2506 Innes Road

Response to Deficiencies
Site Plan Control Application
October 23, 2024

2506 Innes Road - Site Plan Control Application

RE: Consolidated Response to Deficiency Review Comments
2506 Innes Road - Site Plan Control Application

LANDSCAPE PLAN

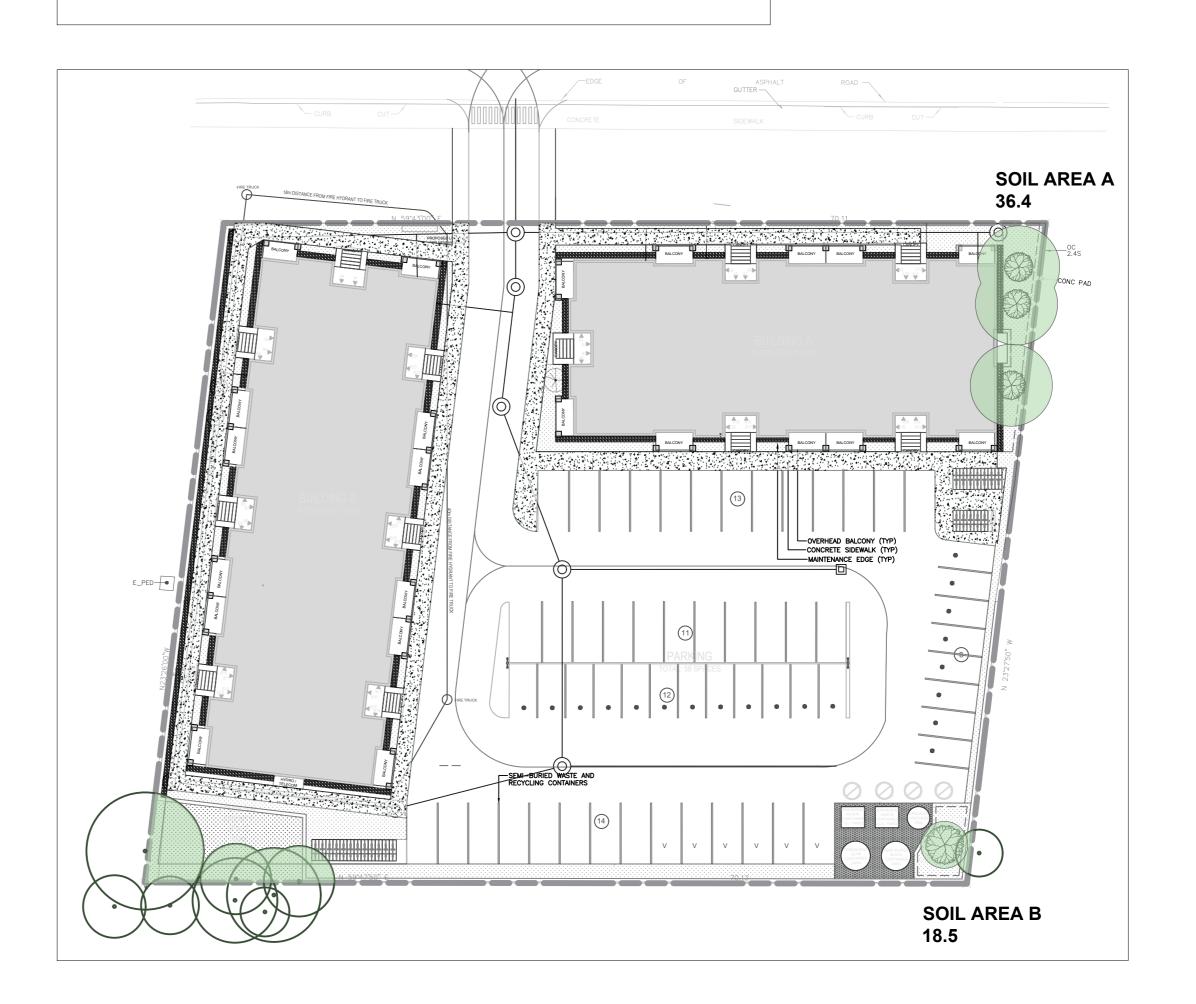
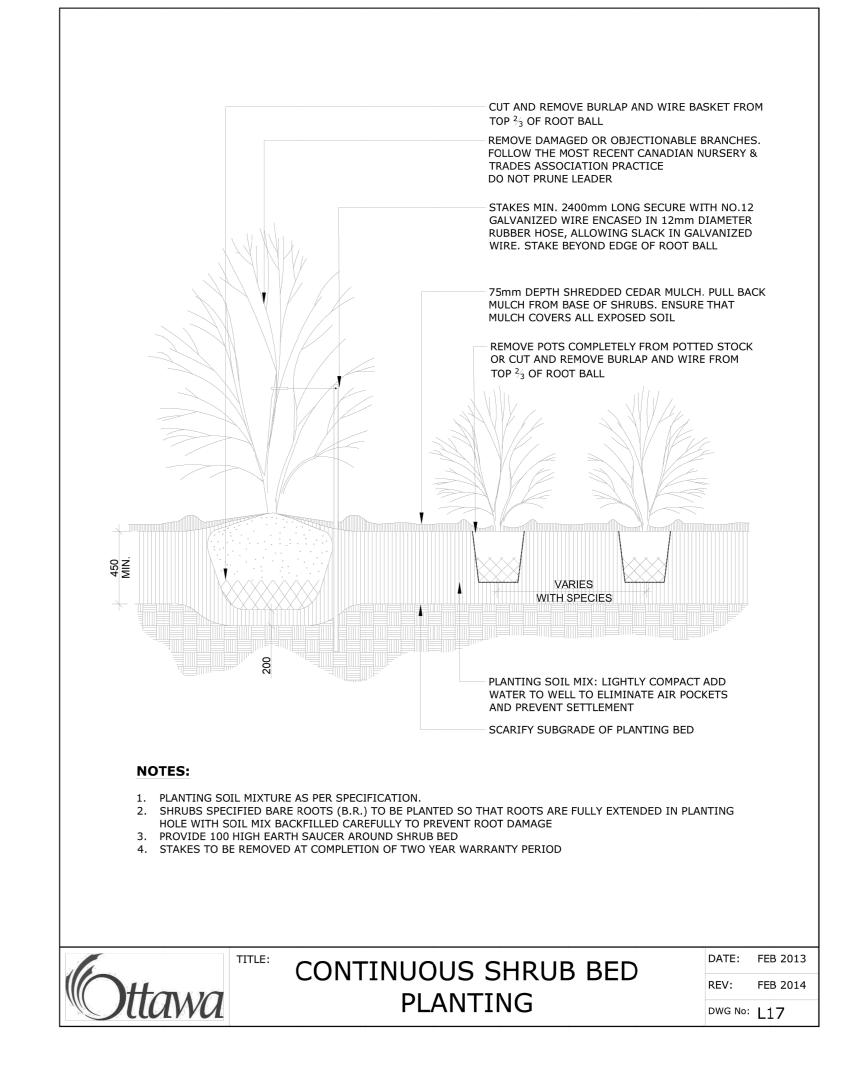
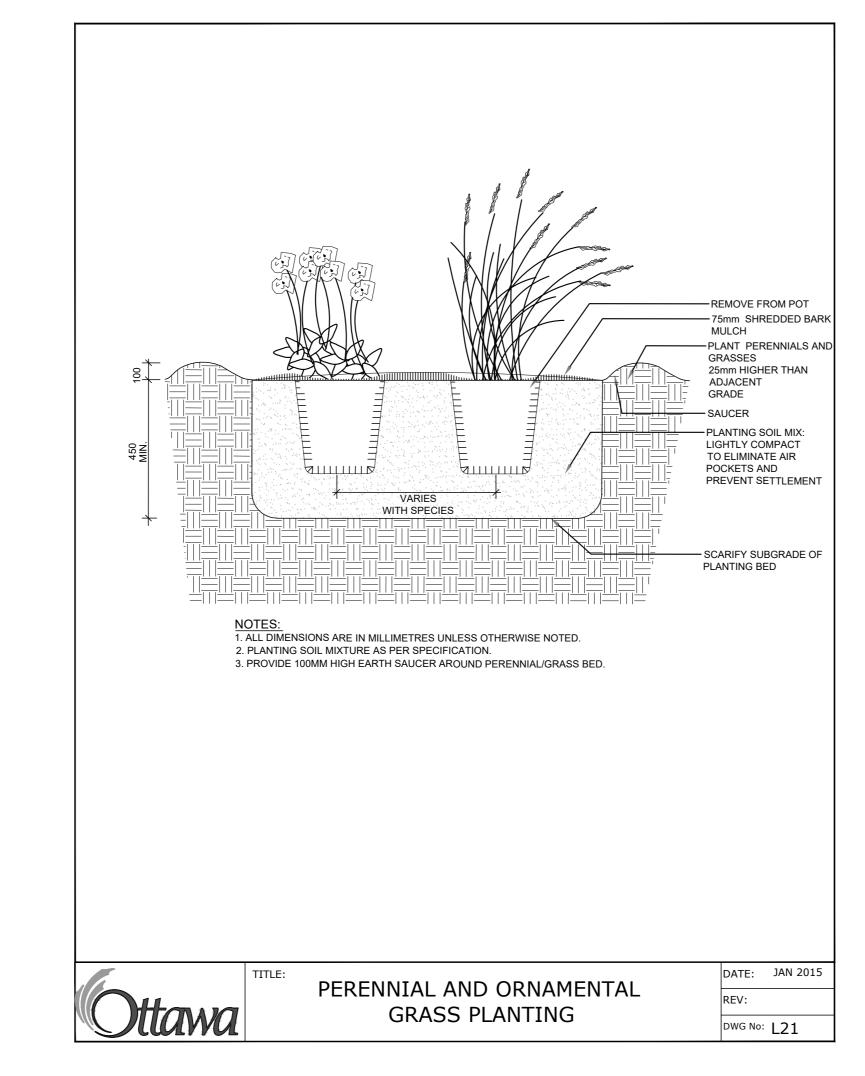
Deficiency #17	All required information added to the site plan and elevations.
Elevations	
Deficiency #18	Existing grade added.
Deficiency #19	Overall height of the building now provided.
Zoning Confirmation Report	
Deficiency #20	The Zoning Confirmation Report has been revised.
Urban Design	
Deficiency #21	<ul style="list-style-type: none"> a. Response to pre-app comments no longer mandatory and as the design has changed substantially, please read the submitted Urban Design brief for a design rationale. b. Alternative plans included in the Urban Design Brief. c. Included within the Arch Set and Urban Design Brief d. No cross-sections were created for this architectural package. e. Included within the revised Urban Design Brief.
Landscape Plan	
Deficiency #22	Required information added.
Planning Forestry	
Deficiency #23	Discussions on tree removal are ongoing neighbouring property owner.
Deficiency #24	Tree replacement is now proposed on the landscape plan.

Deficiency #25	<p>The direction from the OP is informative to our approach, However, it is standard to understand should as encouraged, and shall as mandatory. This deficiency may be better represented as a comment on the application.</p> <p>With the being said, we have adjusted the site plan to allow the preservation of existing trees wherever feasible.</p> <p>Proposed trees are added where feasible, taking into account servicing and soil volume restrictions.</p> <p>Canopy coverage has been increased to 11.6%.</p>

Drawing Title
GRADING PLAN

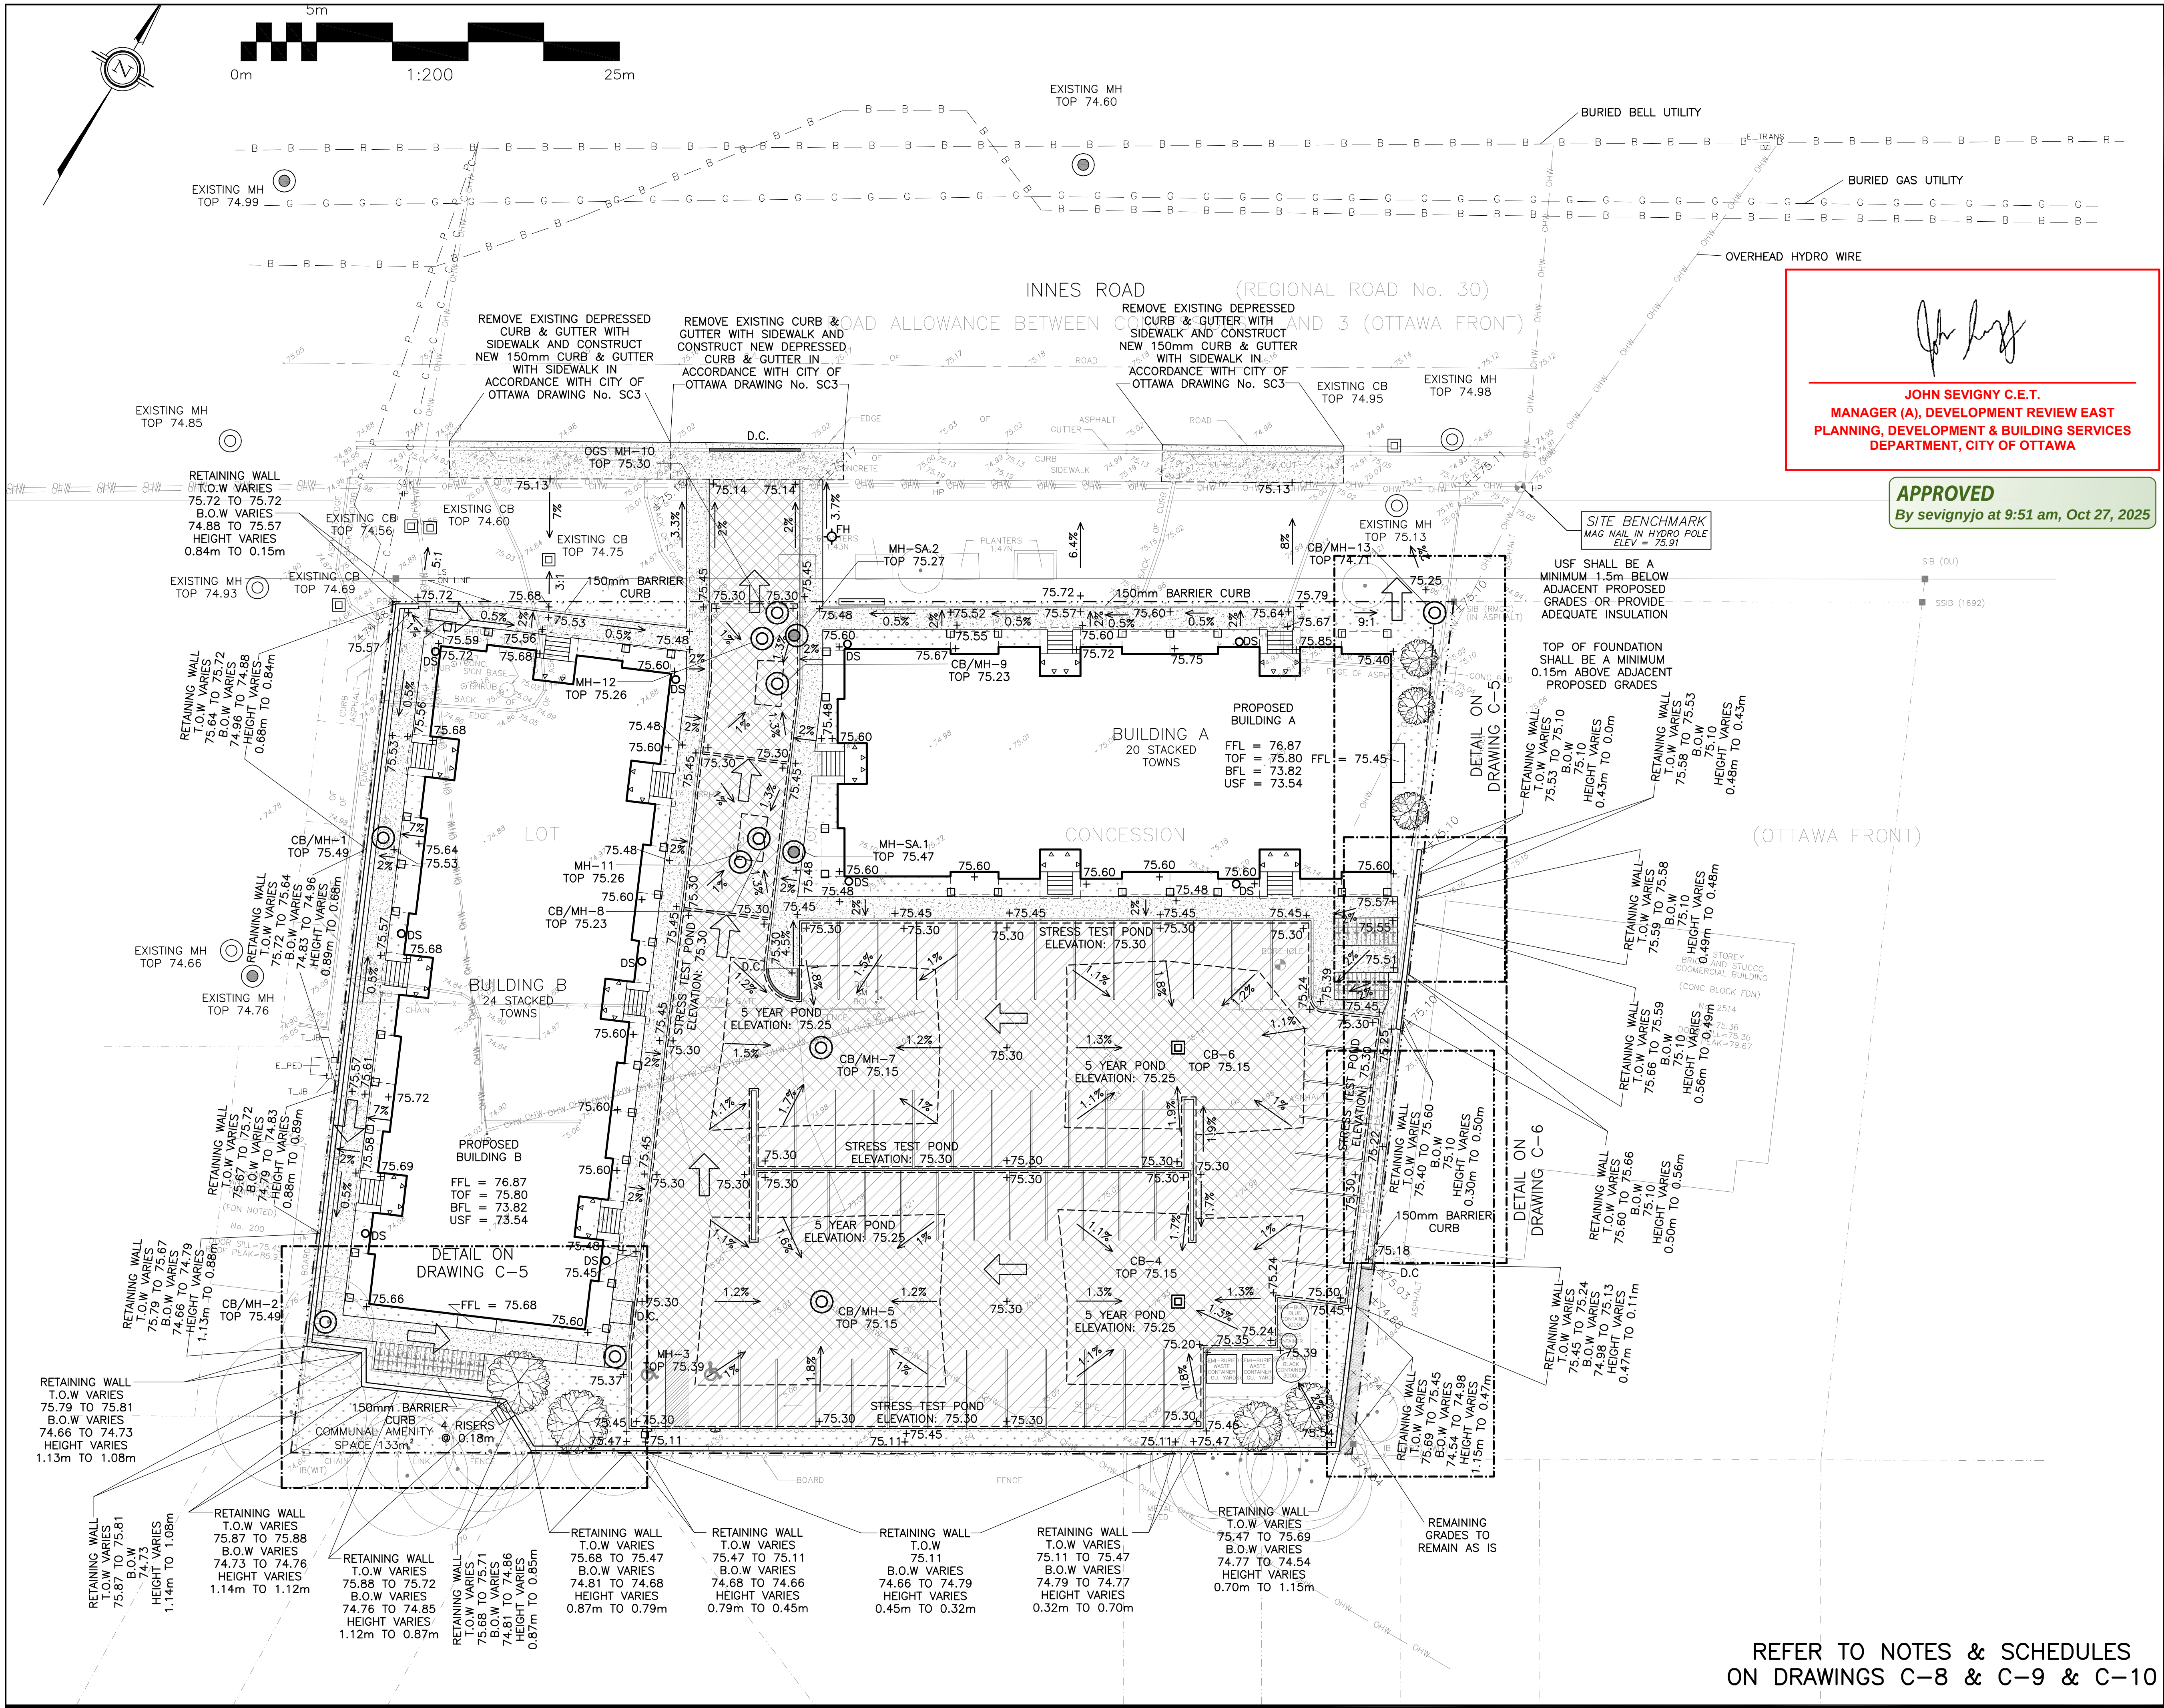
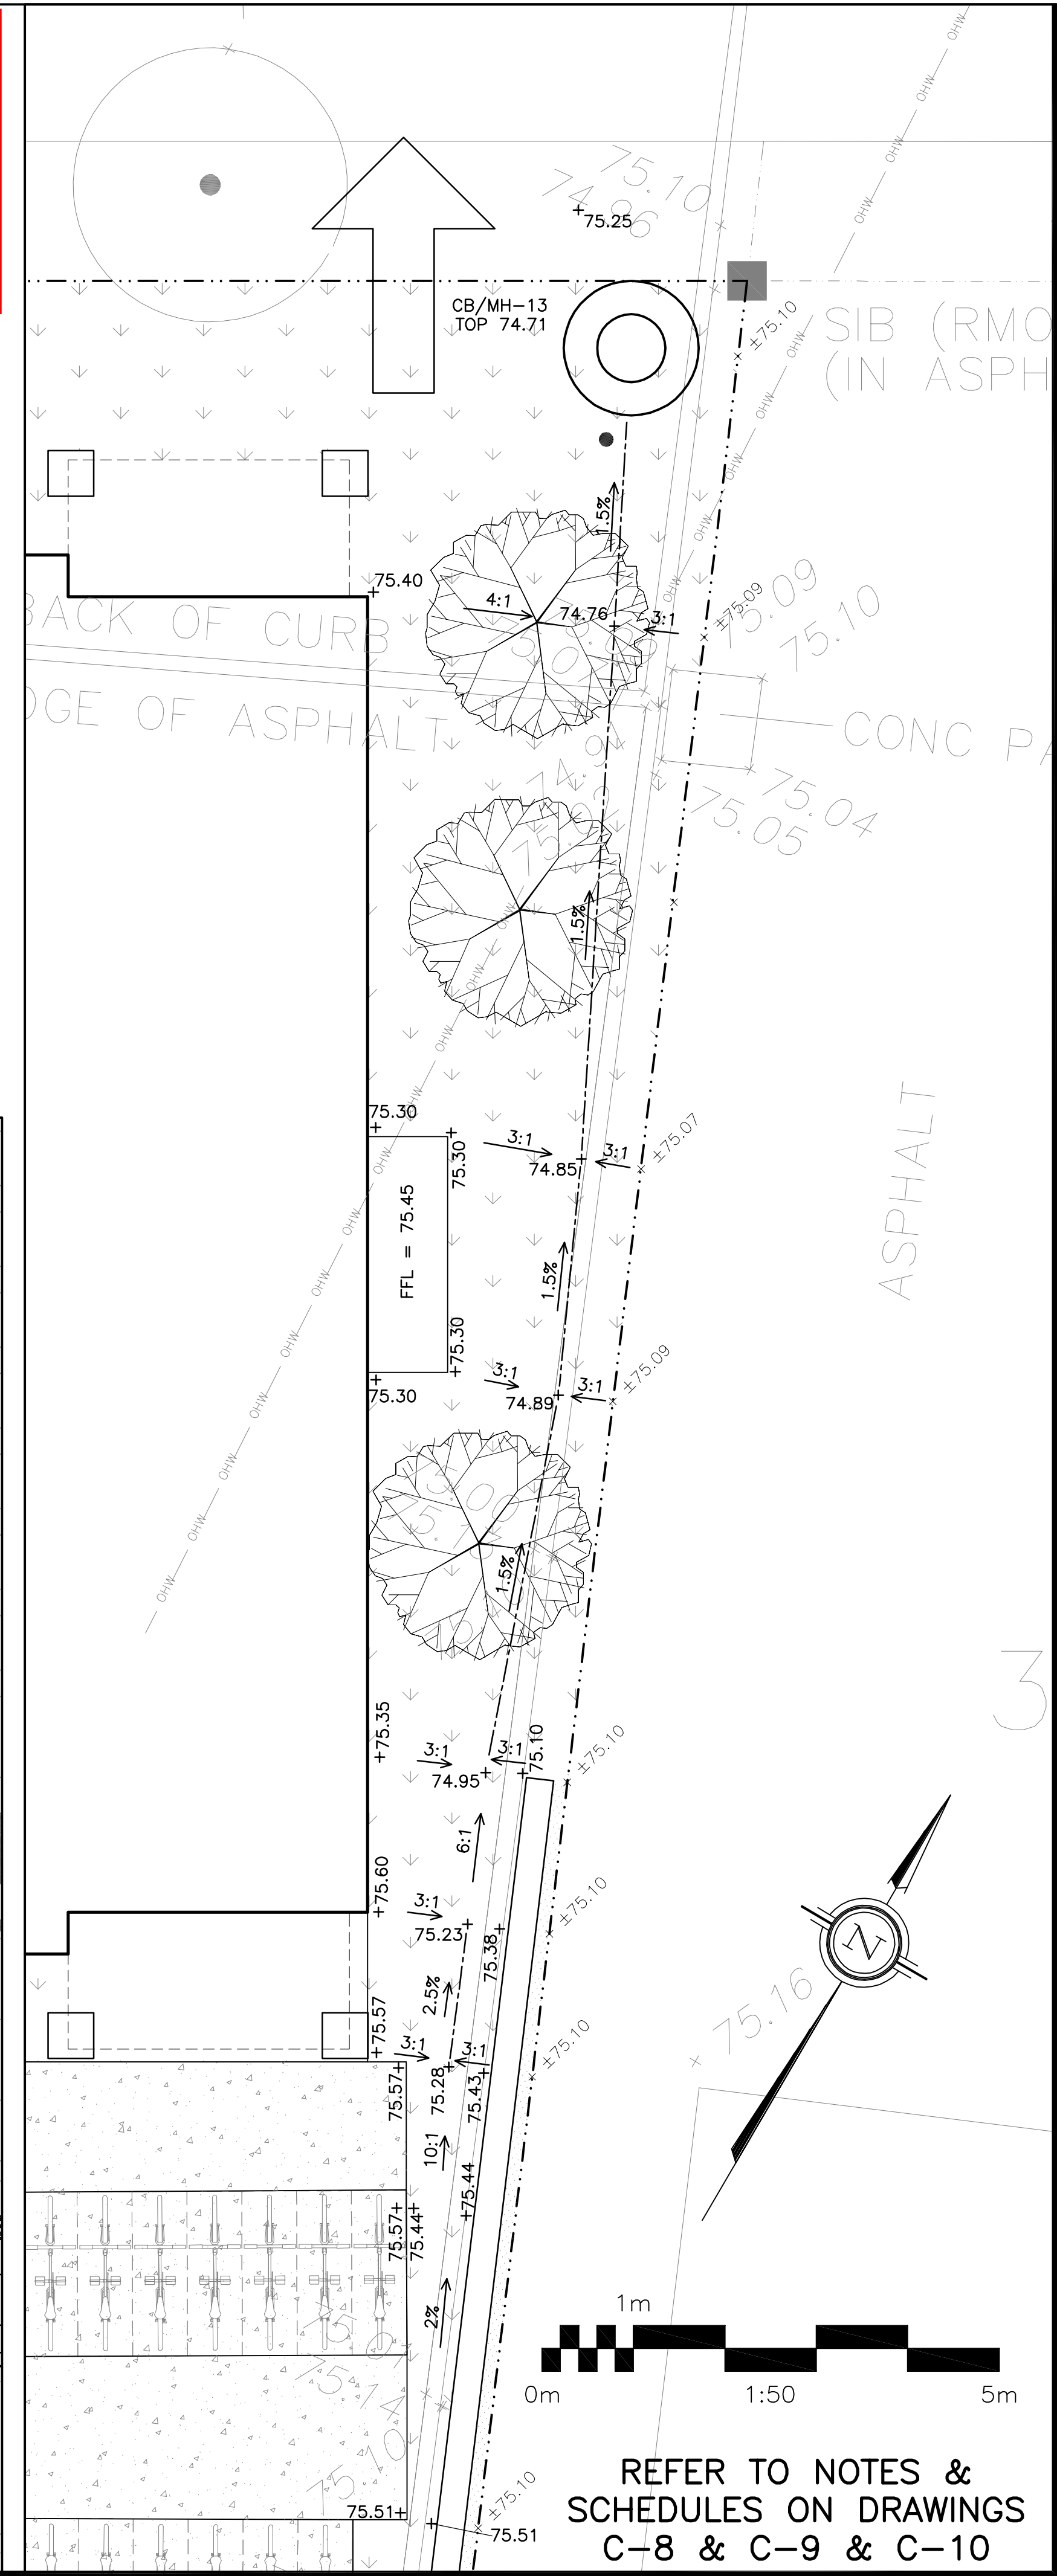
Comments:	Response
Engineering	
Grading Plan	
Deficiency #1	See the revised Grading Plan in submission package now including five metres of topographic details outside of the property line.
Deficiency #2	Grading Plan updated to address these concerns. Amenity Area is now more easily accessible.
Phase 2 Environmental Site Assessment	
Deficiency #3	See Phase 2 Environmental Site Assessment is re-submitted submission package.
Site Servicing and Stormwater Management Report	
Deficiency #4	Floor areas in the FUS calculations now match that in the Architecture plans. To be conservative the ground and second floor balconies were included in the FUS calculations.
Pre-Development and Post-Development Drainage Plans	
Deficiency #5	There appears to be an existing curb along the east property line preventing the neighbouring property from draining onto the subject property. The 1.5 m landscape buffer sheet flowing ± 0.7 L/s (± 20 mL/m) during the 100-year event over the retaining wall should not be viewed as a waterfall or safety concern.
